Planning Services Sign Permit Review Form

Date of Submittal	Application Number	Applicant	Landowner
1/10/2023	SIGN2301-0001	J Signs and Graphics	Elmwood Holdings LLC

Contact Person	Contact Number
Sign Location	910-692-5414
1574 NC 24-87 Unit A	PIN Number
	9584-88-6069.000

Sign Dimensions

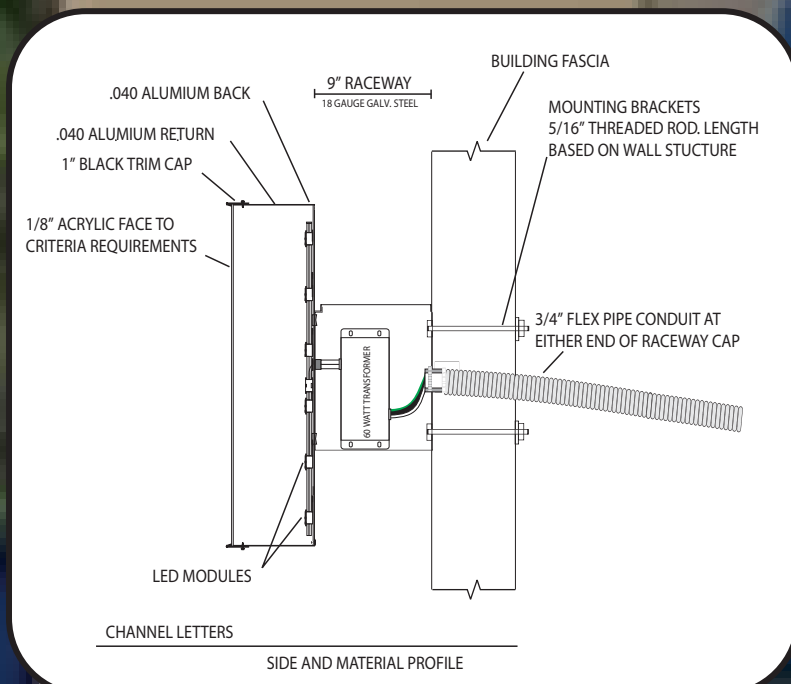
Comments	<p>1. Please provide the length of the mounting wall. Wall signage is permitted at this location by the total liner ft. of mounting wall, 1:1.</p> <p>2. More information is needed. Will the wall sign be illuminated?</p>
-----------------	---
